Our Ref: AW/302/11/
Your Ref:

Please ask for:
Miss C Burrows
01903 737500 Ext 37459
30th November 2011

Front and rear single storey extension
211 Aldwick Road Aldwick

EXISTING ELEVATIONS

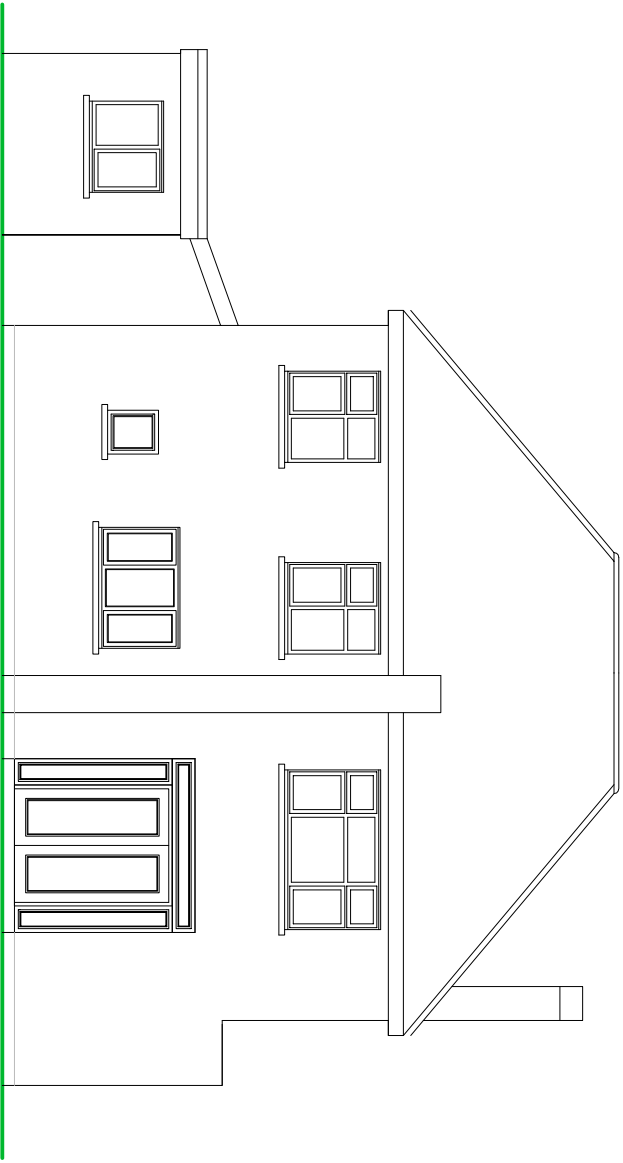
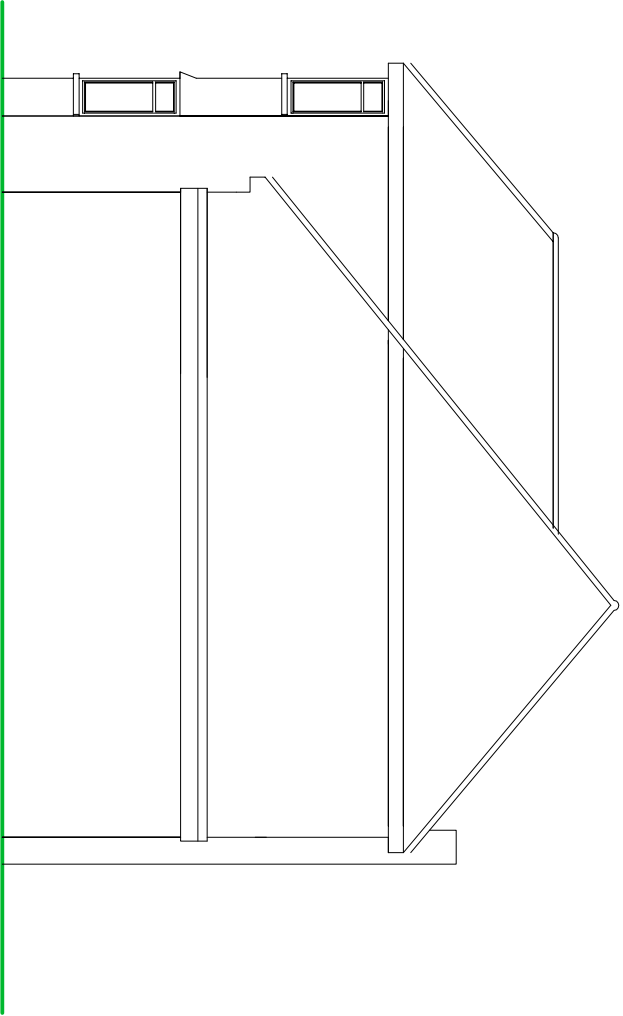
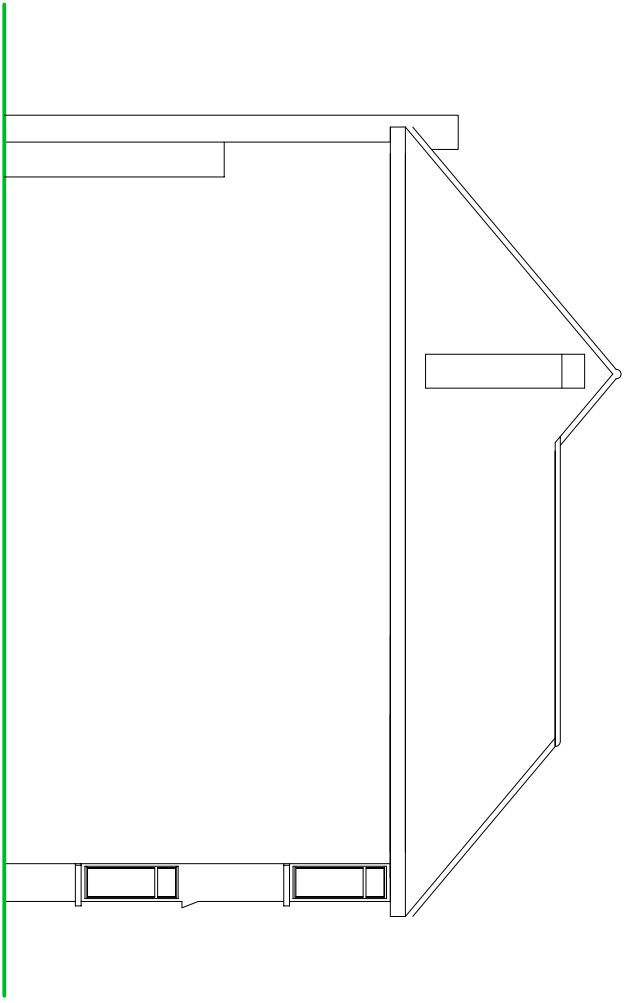
Please provide 1 electronic or 3 paper copies of revised existing and proposed elevations as the garage window (rear elevation) has been omitted from the plans submitted, in accordance with the guidance notes available on our website detailed below (click on National List).
